Wells Fargo  
3001 78TH Ave SE  
Mercer Island, WA 98040  
Permit: DSR24-007

Corrections Response 5/22/24

Site Plan (Scale 1"=20'-0")

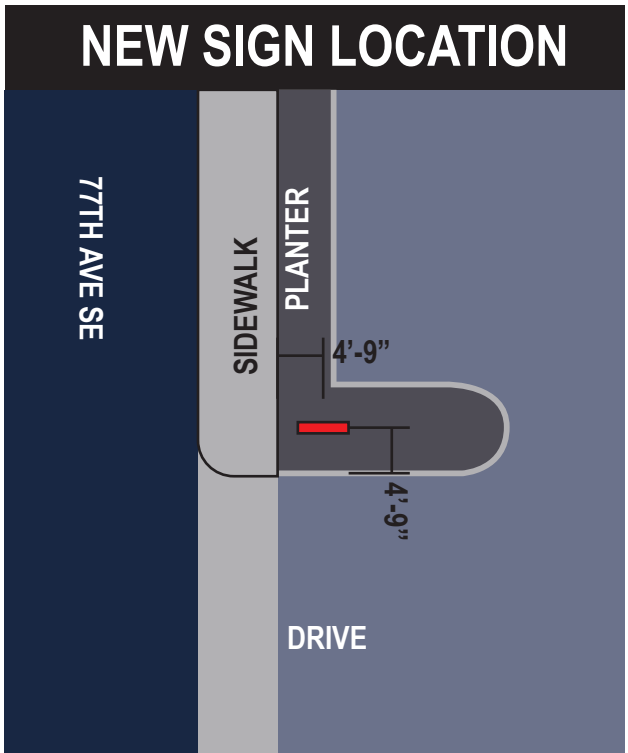
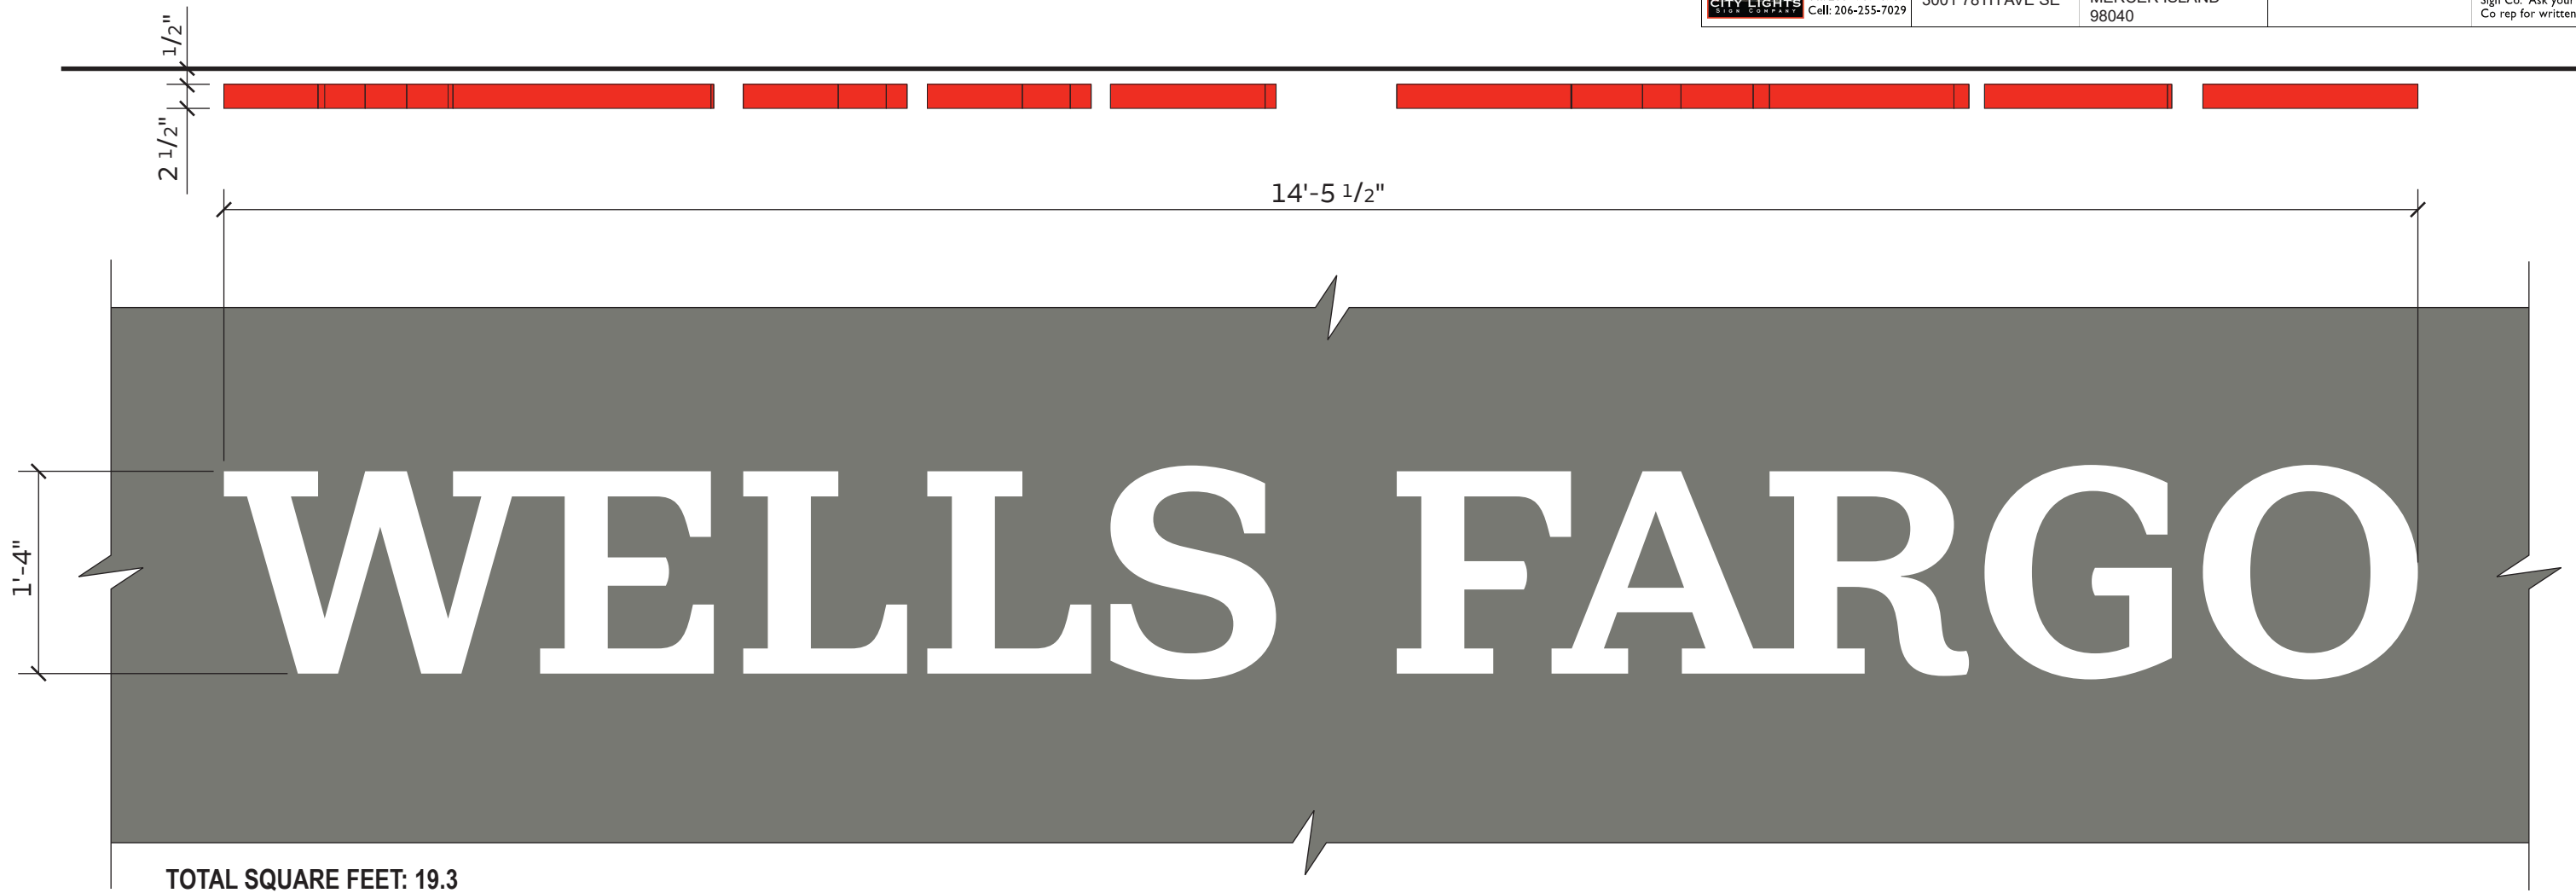
Show the city trees location and excavation outside city property. It is recommended that a certified arborist be on site to use best management practices if tree roots are discovered and need to be cut.

Please show the property line and existing city storm system on the site plan, there is an existing public storm pipe and city tree in the area of the new footing.

Please make sure that the sign and footings will not be in the city Right of Way, and no impacts to the city storm system.

Show the dimension between the city ROW limit and the new sign. Note: the edge of the sidewalk is not the ROW limit.

Plans have been updated specifying property line and tree location. Obtaining arborist to be onsite while holes are dug.

Response: Property line and storm city shown on plans with dimensions
